Your ref: 3/2017/0607

Date: 16th August 2017

Planning Application 3/2017/0607: Conversion of the former Punch Bowl Inn (Grade II listed building) into 5 Holiday Lets and Café, including demolition and extensions. New pitch holiday lodge park with 15No units within curtilage; Former Punch Bowl Inn, Longridge Road, Hurst Green BB7 9QW

GROUND FLOOR PLAN AS EXISTING
Scale 1.100

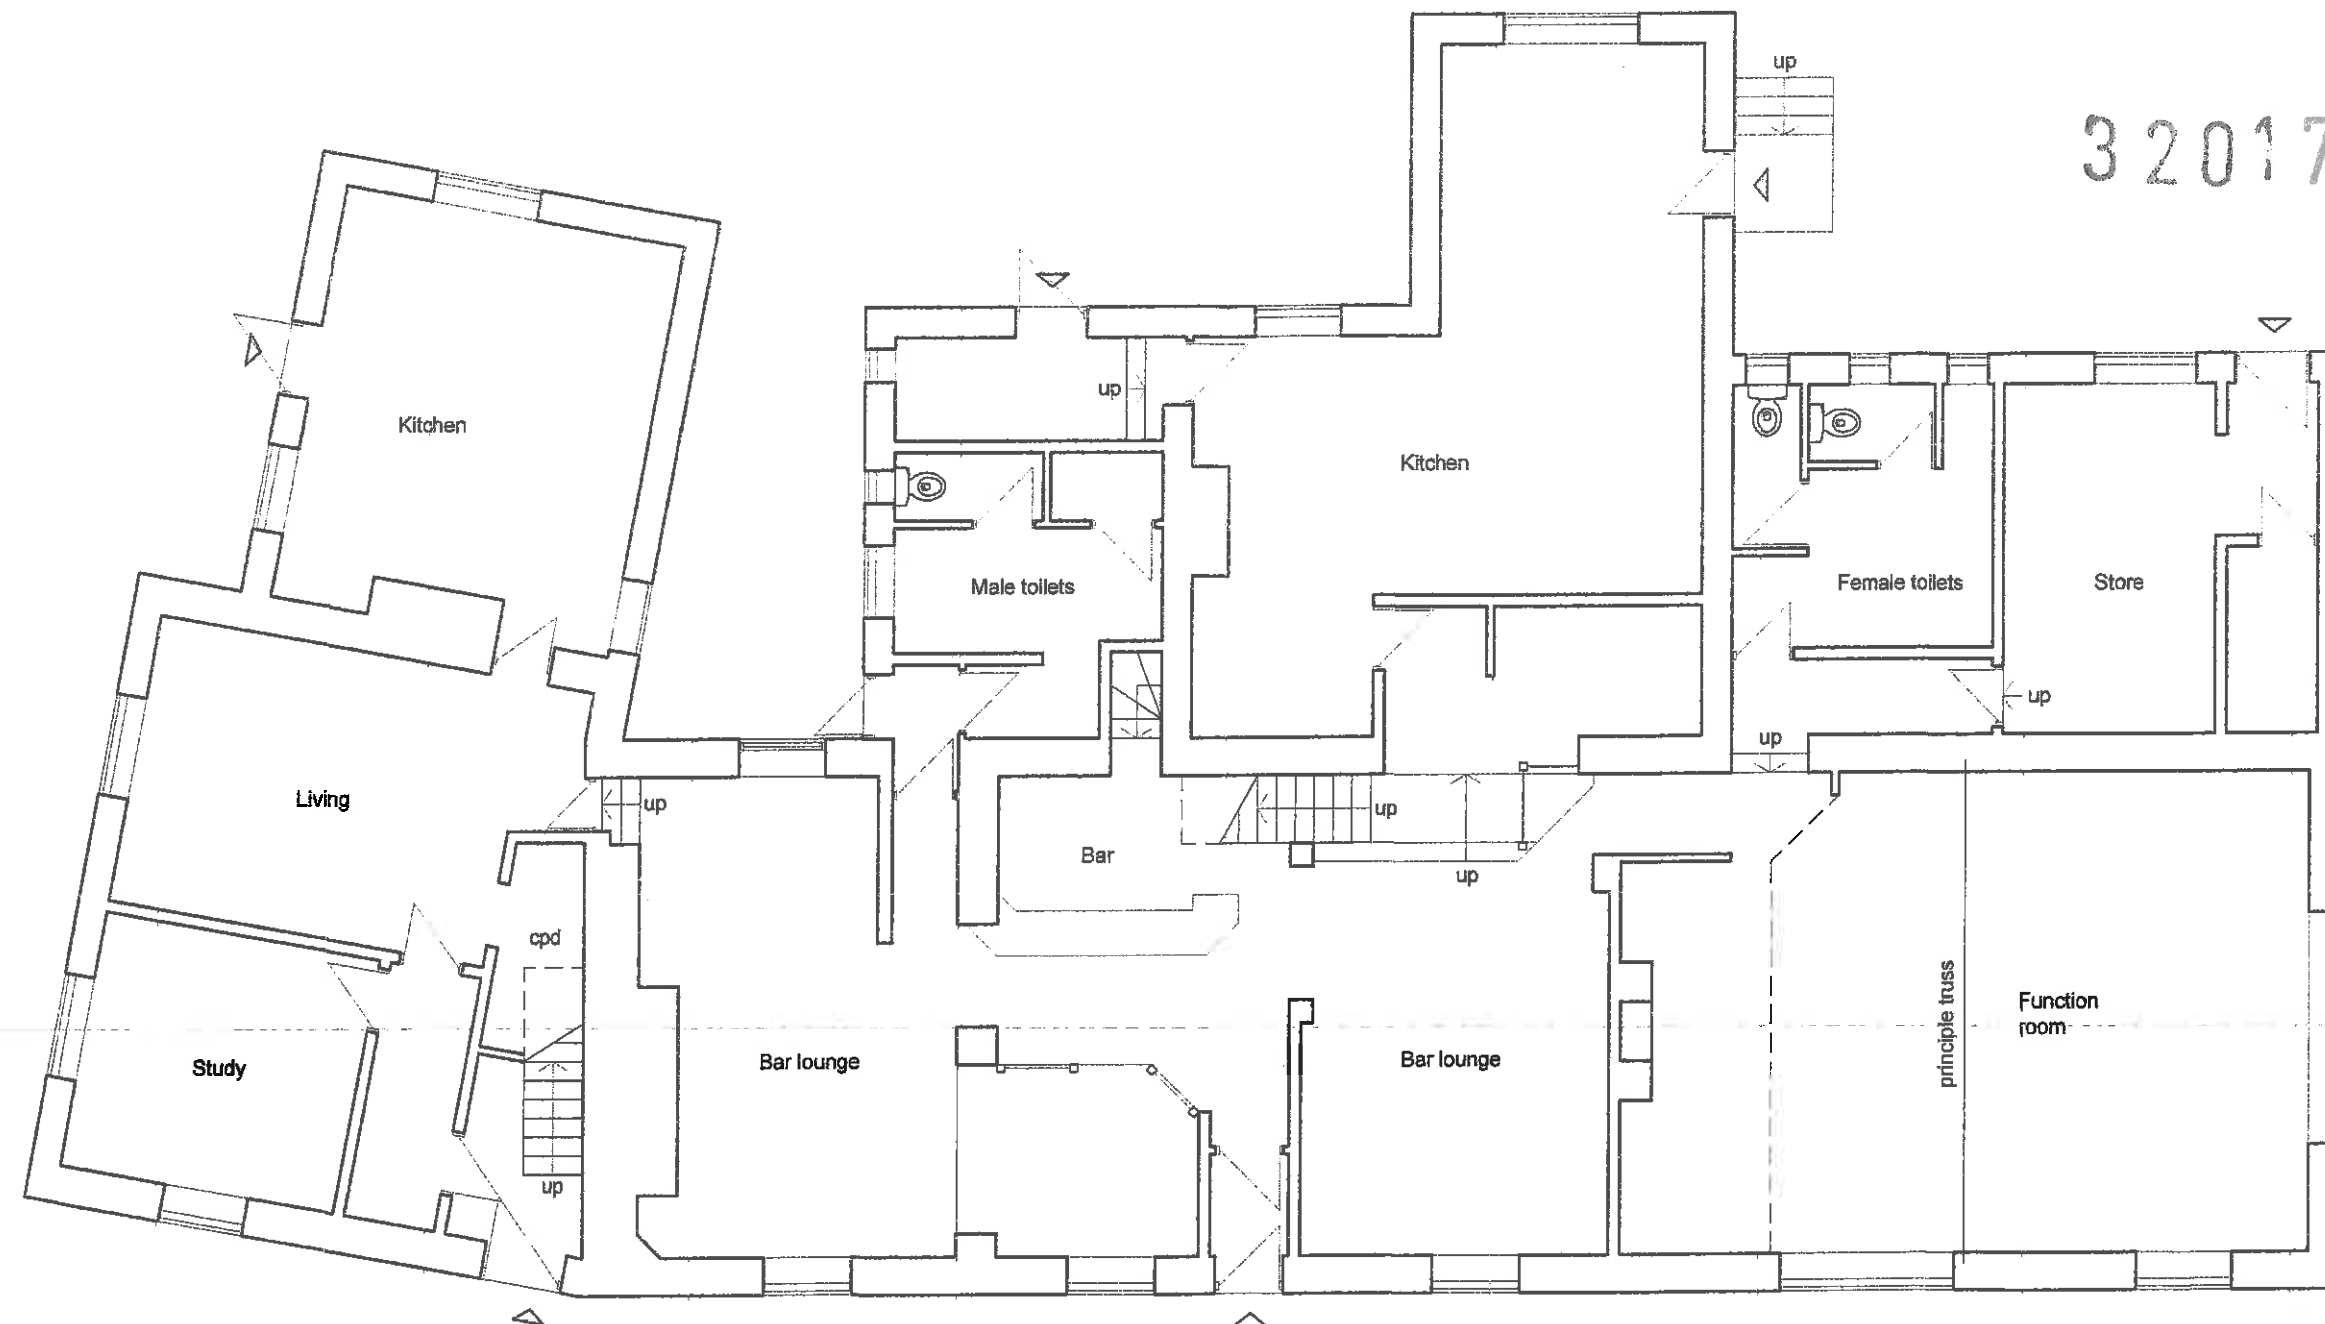
- (i) The loss of the rear barrel vaulted cellar (unless this can be shown to be modern);
- (ii) The loss of much of the rear wall of the right-hand former barn section and partial demolition of the outshut under the catslide roof;
- (iii) The loss of the rear stair in the former cottages and the subsequent changes to the circulation pattern; and
- (iv) The works required to eradicate and repair the dry rot and other damage that has occurred to the building.

We would again recommend that further information is obtained from the applicants before the application is determined. This should include a more thorough assessment of the elements of the building to be altered or repaired and the impact of the proposals upon them. Further details of the rot and other damage to the building and the extent of repair works to the historic fabric required should also be provided.
